# SECOND AMENDED SSDA ARBORICULTURAL IMPACT ASSESSMENT

24,26 & 28 MIDDLE HARBOUR ROAD, LINDFIELD

DA/Reference Number SSDA-82548708

**Addendum Number:** Addendum 03

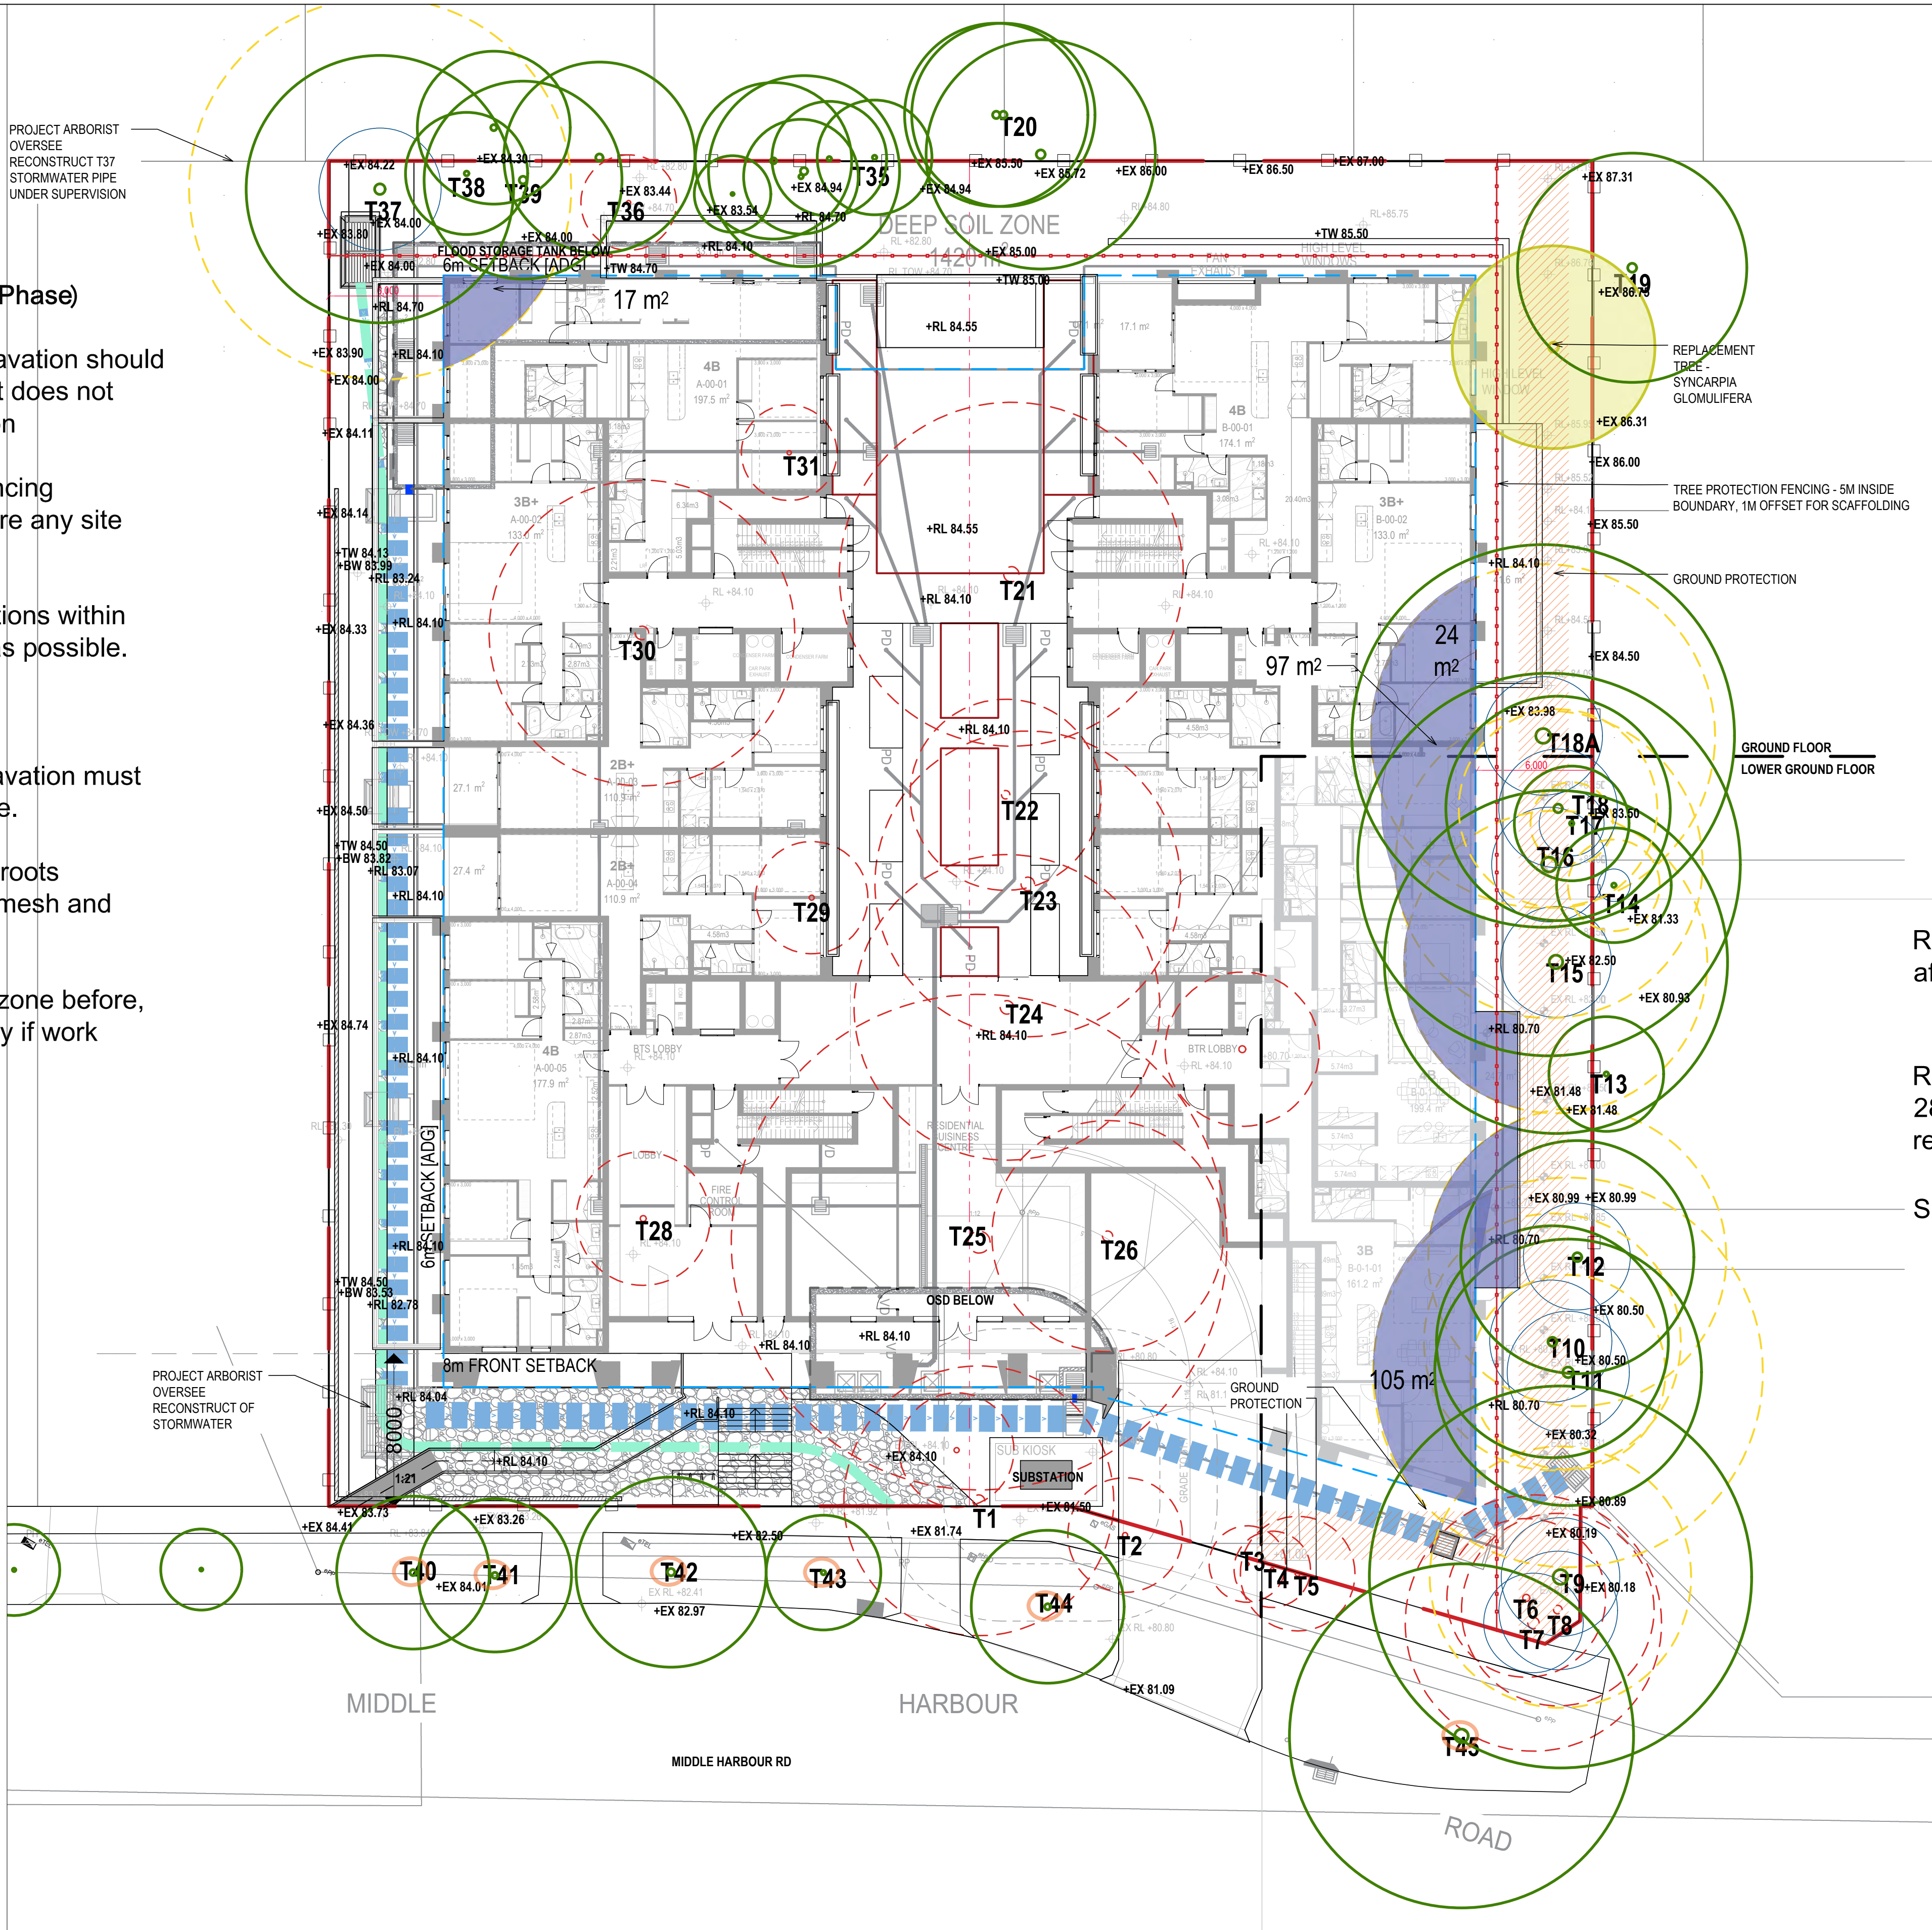
| ITEM 1 | Matters of Concern                                                                                                                                                                                                                                                                                                                                                                                                                                                                                                                                                                                                                                                                                                                                                                                                                                                                                                                                                                                                                                                                                                                                                                                                                                                            | Requests | Comments<br>Recommended Actions                                                                                                                                                                                                                                                                                                                                                                                                                                                                                                                                                                                                                           |
|--------|-------------------------------------------------------------------------------------------------------------------------------------------------------------------------------------------------------------------------------------------------------------------------------------------------------------------------------------------------------------------------------------------------------------------------------------------------------------------------------------------------------------------------------------------------------------------------------------------------------------------------------------------------------------------------------------------------------------------------------------------------------------------------------------------------------------------------------------------------------------------------------------------------------------------------------------------------------------------------------------------------------------------------------------------------------------------------------------------------------------------------------------------------------------------------------------------------------------------------------------------------------------------------------|----------|-----------------------------------------------------------------------------------------------------------------------------------------------------------------------------------------------------------------------------------------------------------------------------------------------------------------------------------------------------------------------------------------------------------------------------------------------------------------------------------------------------------------------------------------------------------------------------------------------------------------------------------------------------------|
| CPHR   | Tree 37                                                                                                                                                                                                                                                                                                                                                                                                                                                                                                                                                                                                                                                                                                                                                                                                                                                                                                                                                                                                                                                                                                                                                                                                                                                                       |          | <p>The civil engineering plans prepared by Xavier Knight require stormwater in the locations shown that are designed to meet the required function, a realignment cannot be made to these elements. It is proposed in the location of tree 37 that use of vacuum suction truck be used to carefully excavate this area, the works will be undertaken under the supervision of a suitable qualified AQF Level 5 Arborist as a condition of consent.</p>                                                                                                                                                                                                    |
